RE: Footing Observations
Front Deck-Boatwright Residence
55 King Soloman Ln.
Cameran, NC

On September 28, 2024, I observed the framing for the front deck at the above referenced site. The observations were compared to the Harnett County deficiencies noted for the September 10, 2024, inspection.

Post Layout

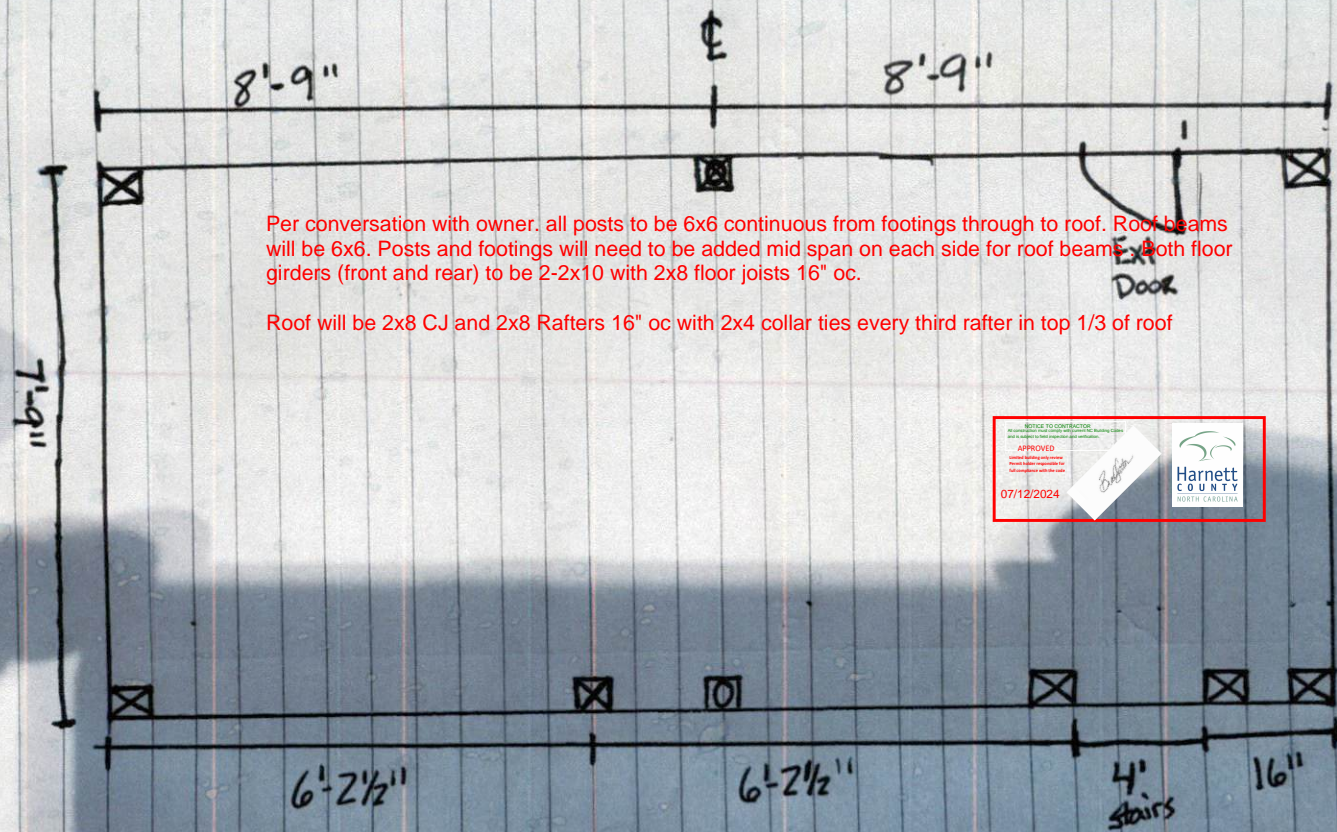
1. The 2X6 handrail for the steps was replaced with a 2X4 handrail.
2. The string bearing has been corrected and has a bearing of at least 3.5 inches.
3. The step height has been corrected and the height of all steps is equal.
4. Flashing has been properly installed.
5. Missing collar and rafter ties have been installed.
6. Roofing sheathing edges are supported with 2X4's connected to the rafters.
7. The band around three sides of the deck consist of three (3) 2x10's. The first 2X10 is connected to the post with two (2) through bolts (1/2" diameter). The remaining 2X10's are connected to the post with at least two (2)-8" long Simpson Strong-Tie screws. Also, two (2) rows of 4" long Simpson Strong-Tie screws were installed on 16" centers horizontally along the band with the screws at least 2" from the band edge. The connections will provide proper support for the floor joists.

8. The screws were removed and replaced with 10d nails at the brackets.
9. The rafters and roof are supported on a 6X6 post with three (3) 2X6's laid flat on top of the post. Based on a roof load of 30 psf, the shear and bending moments developed in the post are less than the allowable shear and moments for this post, and the post will provide suitable support for the roof.
